# CITY OF ALBUQUERQUE

**Re: Las Ventanas at San Isidro  
3737 San Isidro NW  
Request Permanent C.O. - Accepted  
Engineer's Stamp Dated 3-23-13 (File: G13D031)  
Certification dated: 8-31-16**

RE: **Las Ventanas at San Isidro**  
**3735 San Isidro NW**  
**Grading and Drainage Plan**  
**Engineers Stamp Date 3/23/16 (G13D031)**

ENGINEER'S SEAL  DAVID SOULE P.E. #14522	LOT 10B1 AND LOT B2 CANDELARIA PLAZA ADDITION	DRAWN BY JDG
	GRADING AND DRAINAGE PLAN	DATE 03-23-06
 Rio Grande Engineering 1606 CENTRAL AVENUE SE SUITE 201 ALBUQUERQUE, NM 87106 (505) 872-0999		SHEET # 1 OF 1
		JOB #

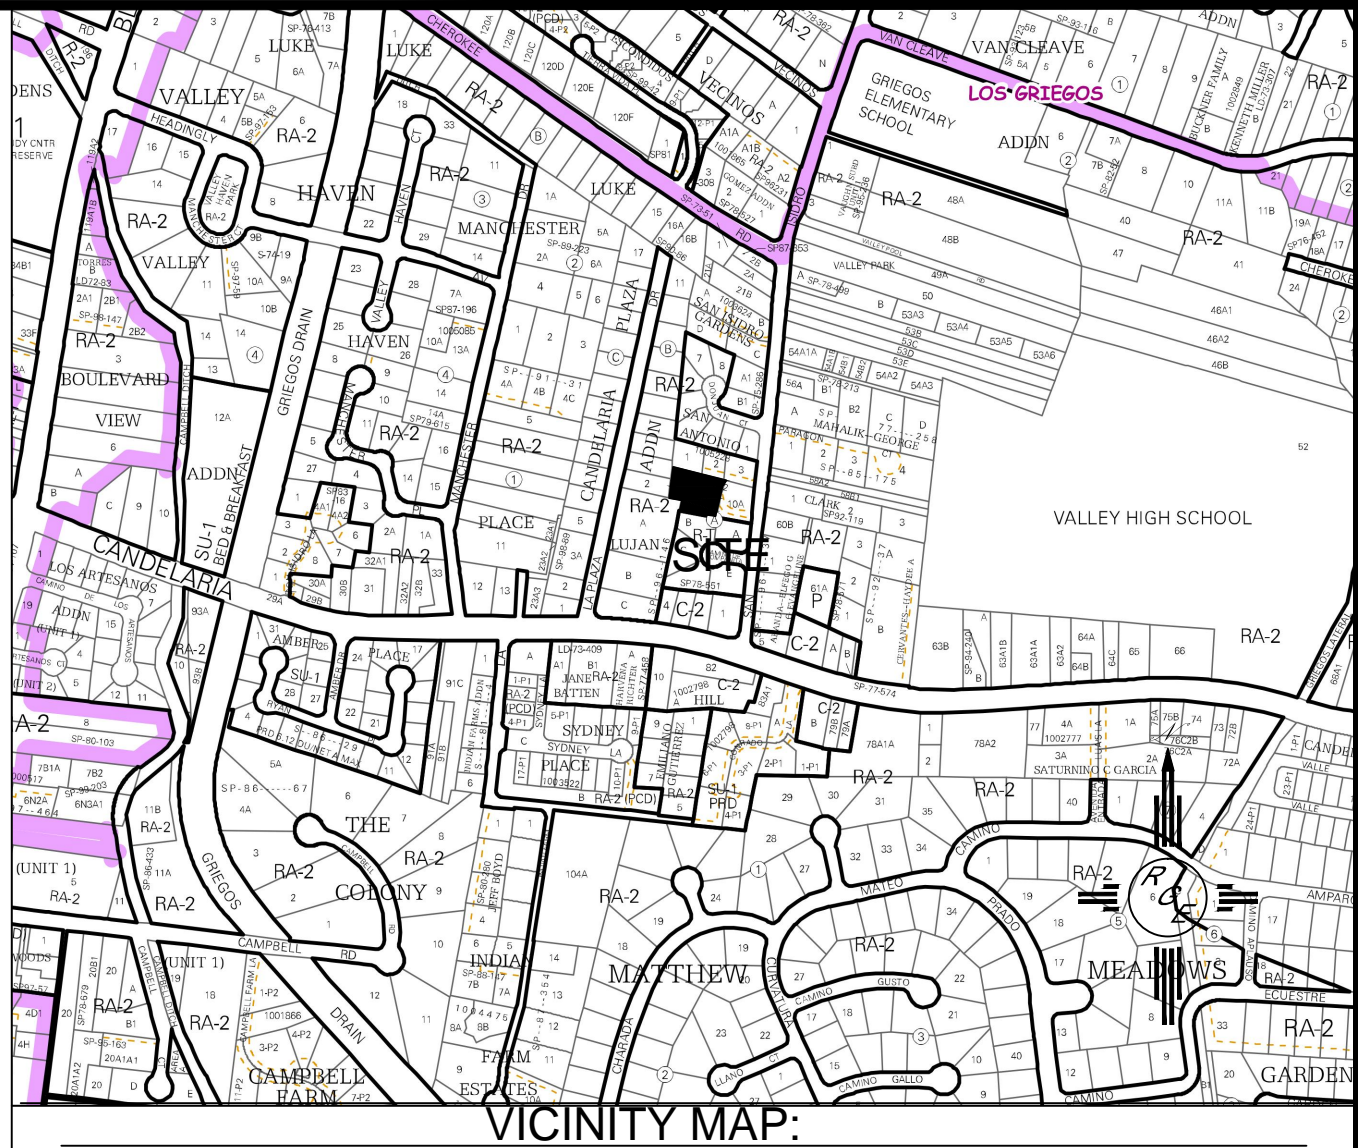
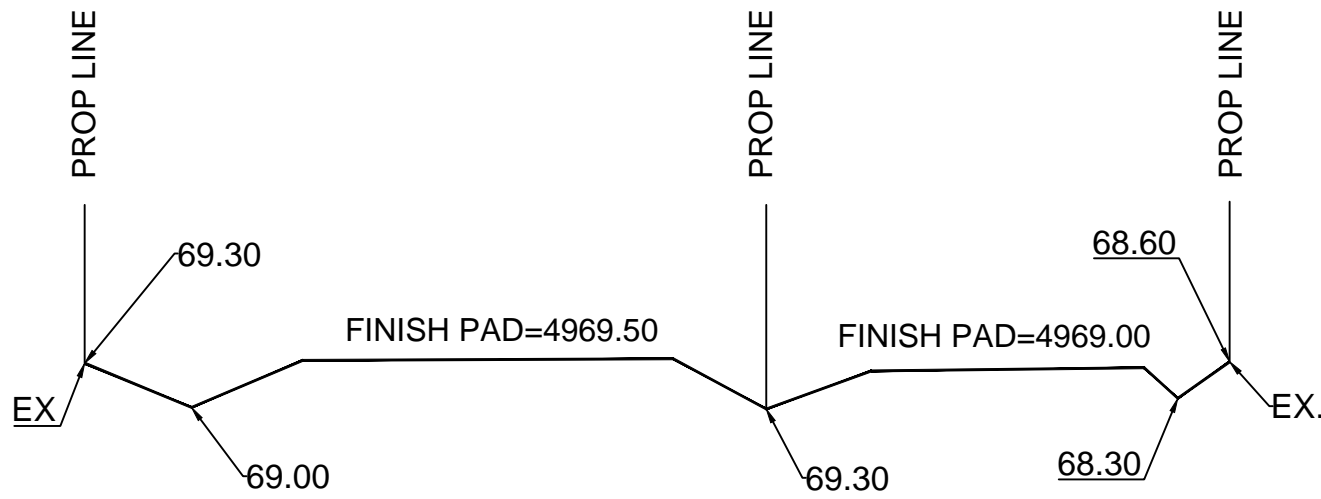
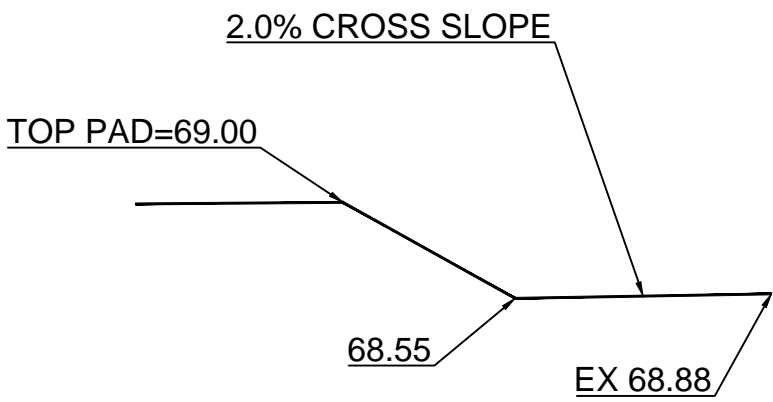
1. Drainage calcs were omitted ( WE HAVE ADDED TO THE PLAN)
2. New spot elevations to cluttered, remove majority of spots. (WE HAVE REMOVED MOST EXISTING ELEVATIONS TO ELIMINAT
3. FF for lot 10-B1 should be at 4969.50. ( WE HAVE ADDED THE FINISHED FLOOR ELEVATIONS TO ALL LOTS)
4. Label existing buildings. (WE HAVE LABELED)
5. Show roof flows. (WE HAVE SHOWN)
6. What is E note at existing buildings? ( WE HAVE REMOVED THE KEY NOTE

We enlarged, the text on the survey shots.
2. The drainage narrative states that no cross-lot drainage exists (except for the access/drainage easement). Please provide a cross-section of the two swales that are implied between lots B2 and B1.

We have added spots and a cross section to show no cross lot drainage
3. Provide additional elevation points (or a cross section) for the access aisle to show if it is intended to have a crown, inverted crown, or sheet flow.

we have added the spots there is solid wall on south so we are superlevating to north
4. In the re-submittal, please fix minor labeling, such as the reference to the 10-year storm and column headings in the drainage narrative; Lot numbers; 4949 Elevation Contour; turn off the leader lines for the easement dimensions, etc. Label San Isidro Rd.

ENGINEER'S SEAL  DAVID SOULE P.E. #14522	LOT 10B1 AND LOT B2 CANDELARIA PLAZA ADDITION	DRAWN BY JDG
	GRADING AND DRAINAGE PLAN	DATE 03-23-06
 1606 CENTRAL AVENUE SE SUITE 201 ALBUQUERQUE, NM 87106 (505) 872-0999		SHEET # 1 OF 1
		JOB #

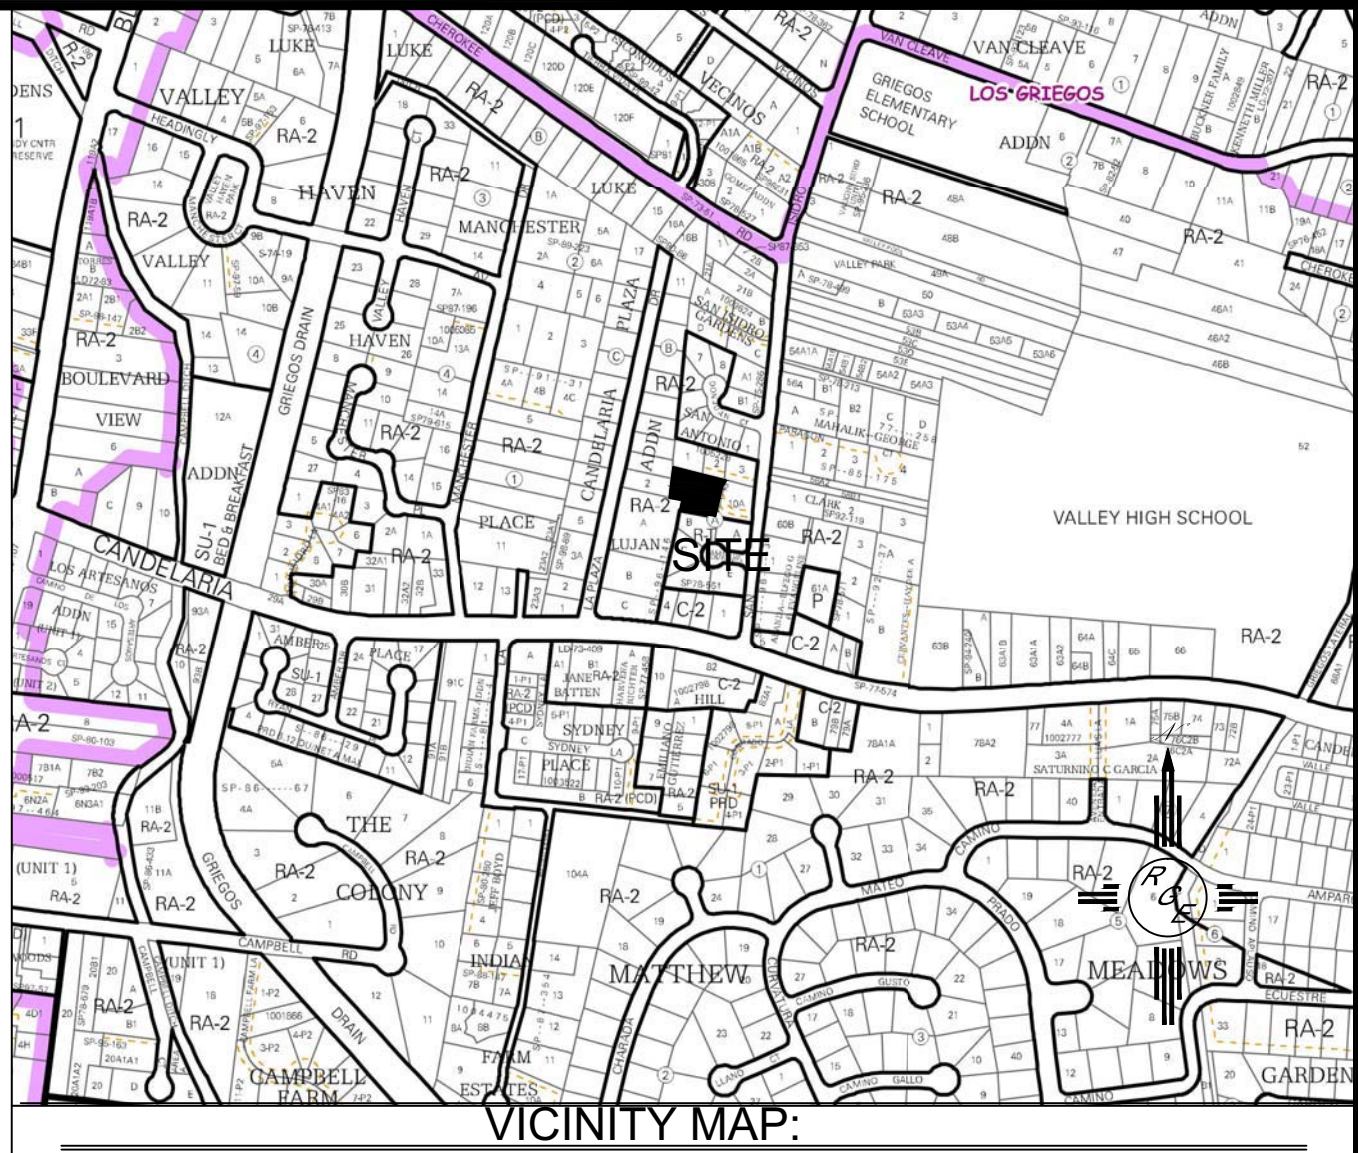
- Both ponds are present however neither is landscaped. During the landscaping phase the volume (size), shape and integrity of the ponds must be maintained per the City of Albuquerque drainage ordinance.
- The ponds must be stabilized with landscaping within 90 days from the date of this letter.
